From: Michael Eastham <Michael.Eastham@arun.gov.uk>
Sent: 16 March 2020 09:31
To: Planning.Responses <Planning.Responses@arun.gov.uk>
Subject: FW: BE/15/20/DOC Full Condition 45

Are you satisfied with the details submitted under **Condition 45** relating to levels and the height of the development?

PHASE 2 EXTERNAL LEVELS
FOR DOC 10 & 45

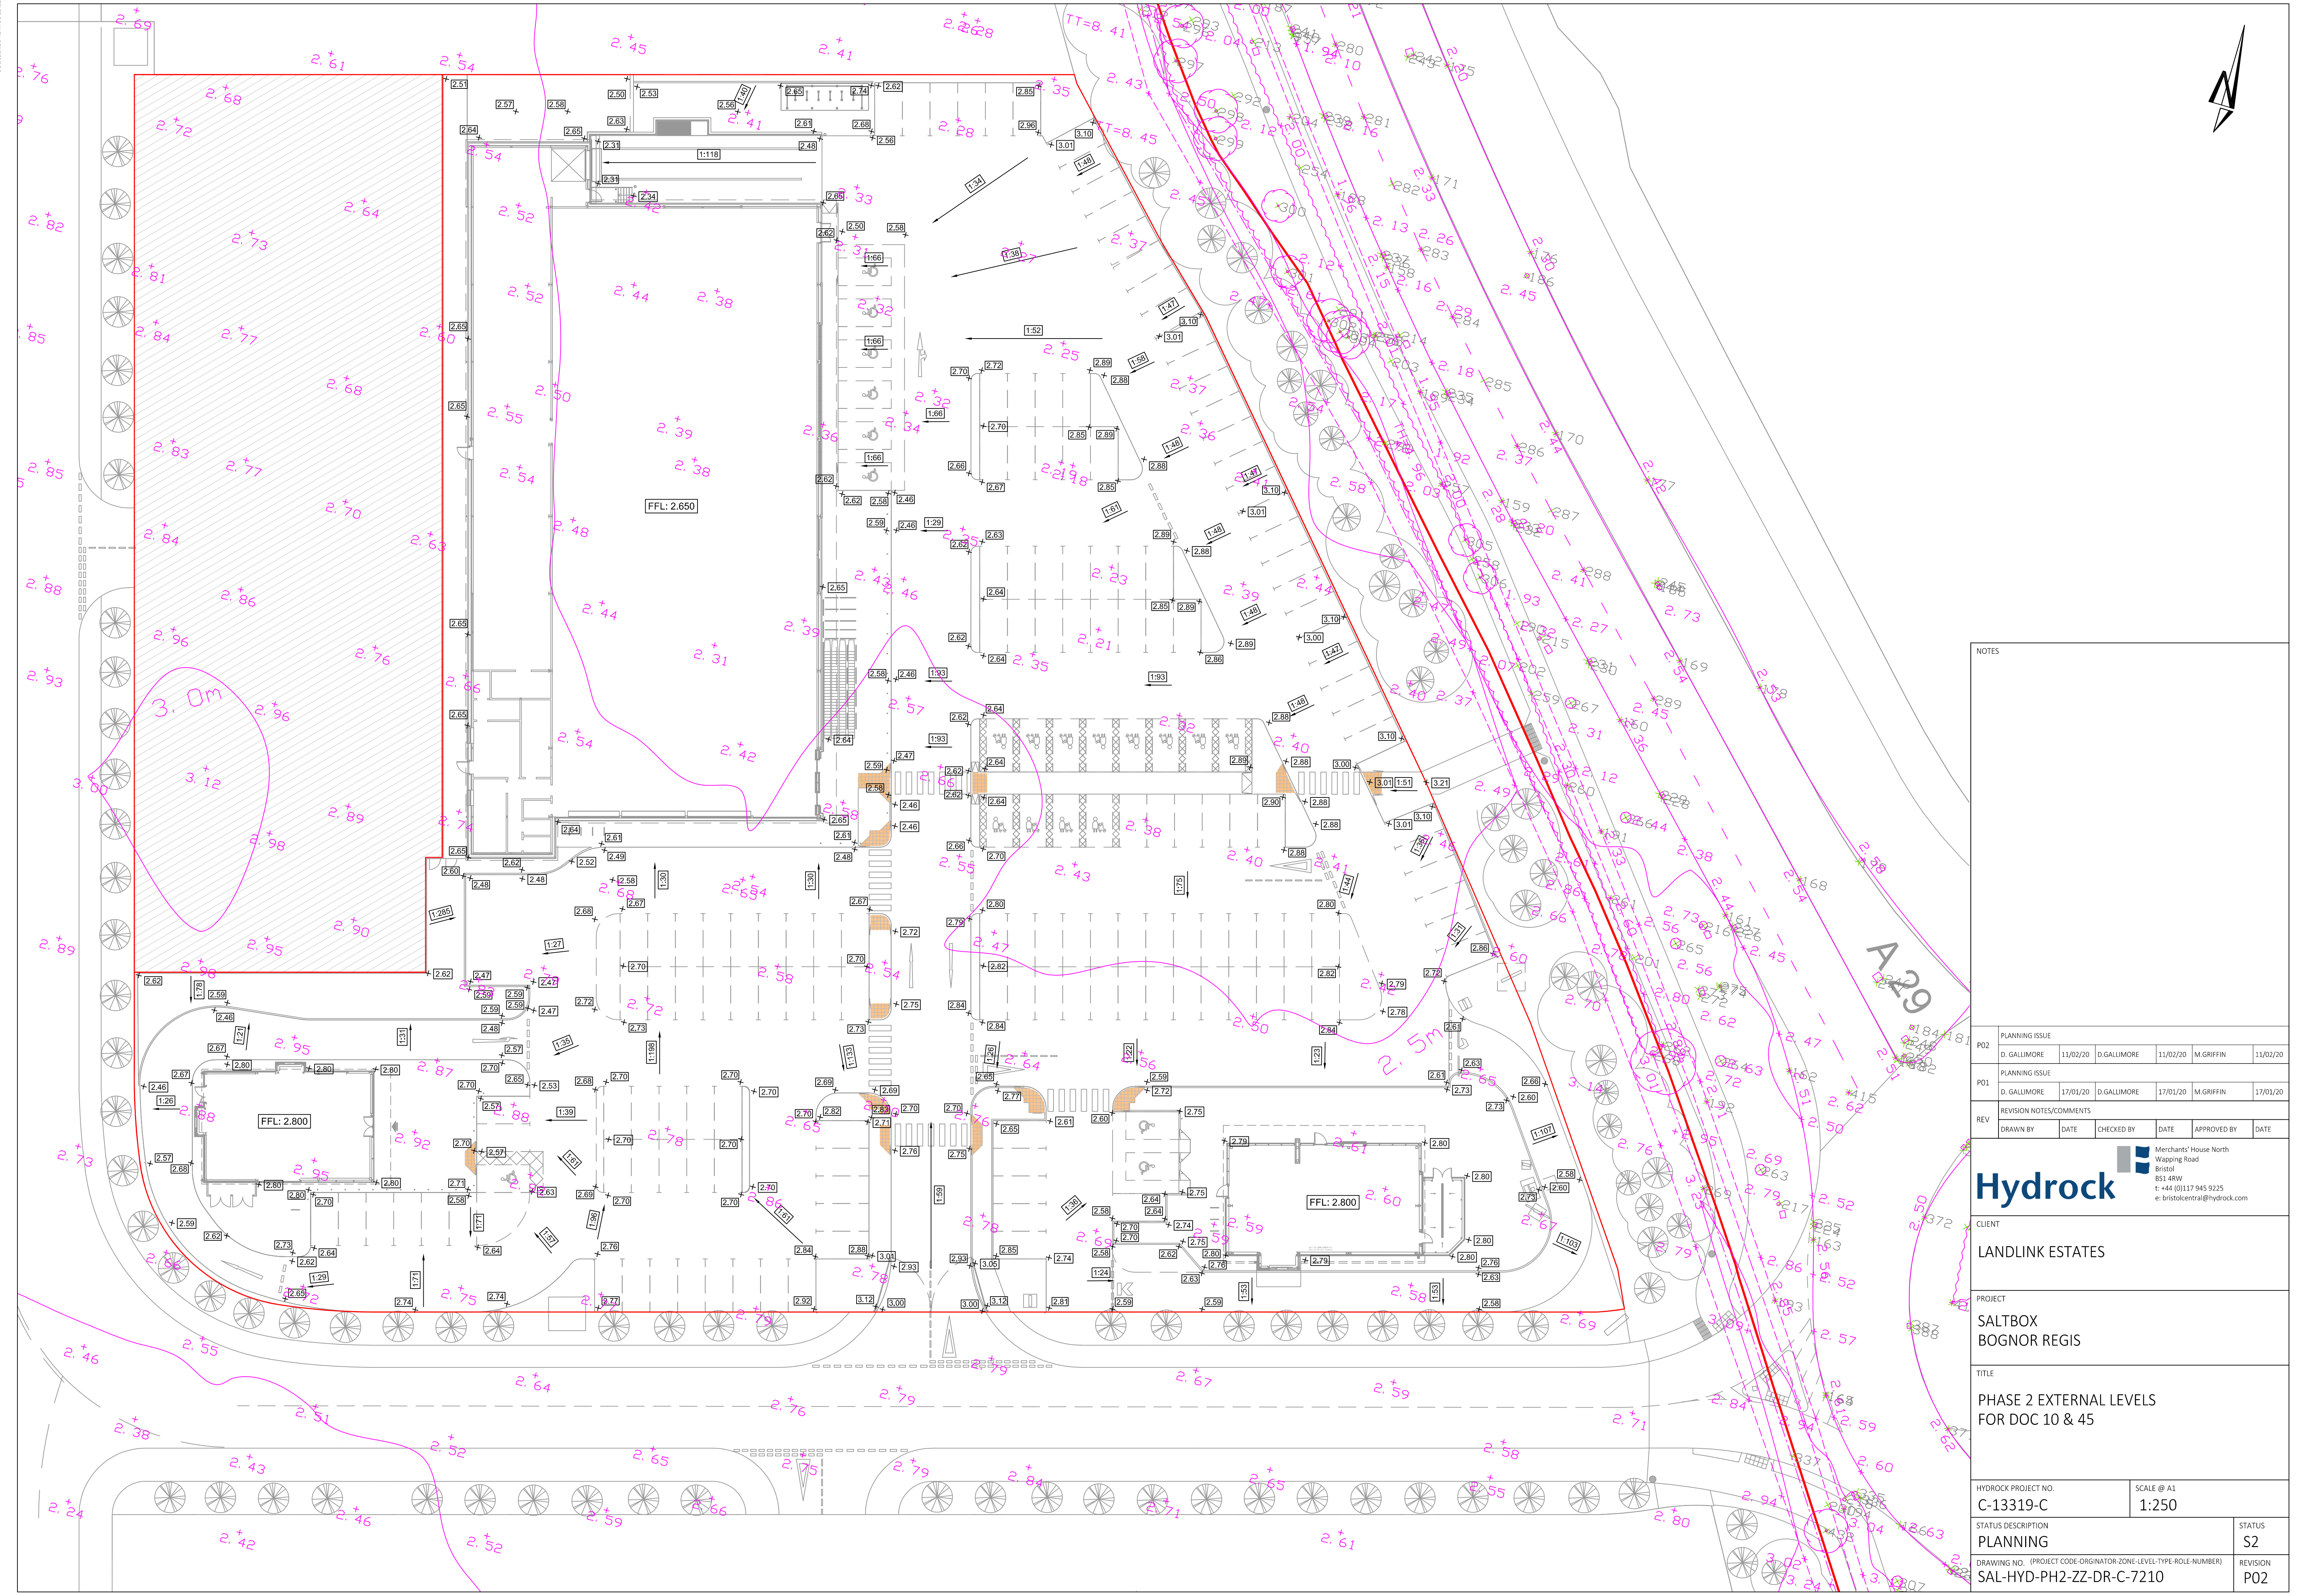
Roger is confused that the other, larger unit are FFL 3.2m whereas these are 2.6m – they are still above the flood levels but where did the extra 600mm go? Perhaps it's an operational thing for the warehouse?

I am slightly confused that the other, larger unit are FFL 3.2m whereas these are 2.6m – they are still above the flood levels but where did the extra 600mm go? Perhaps it's an operational thing for the warehouse?

Yes, it's because the larger unit (1) will have dock doors like unit 2, so the FFL inside is higher than where the lorries park.
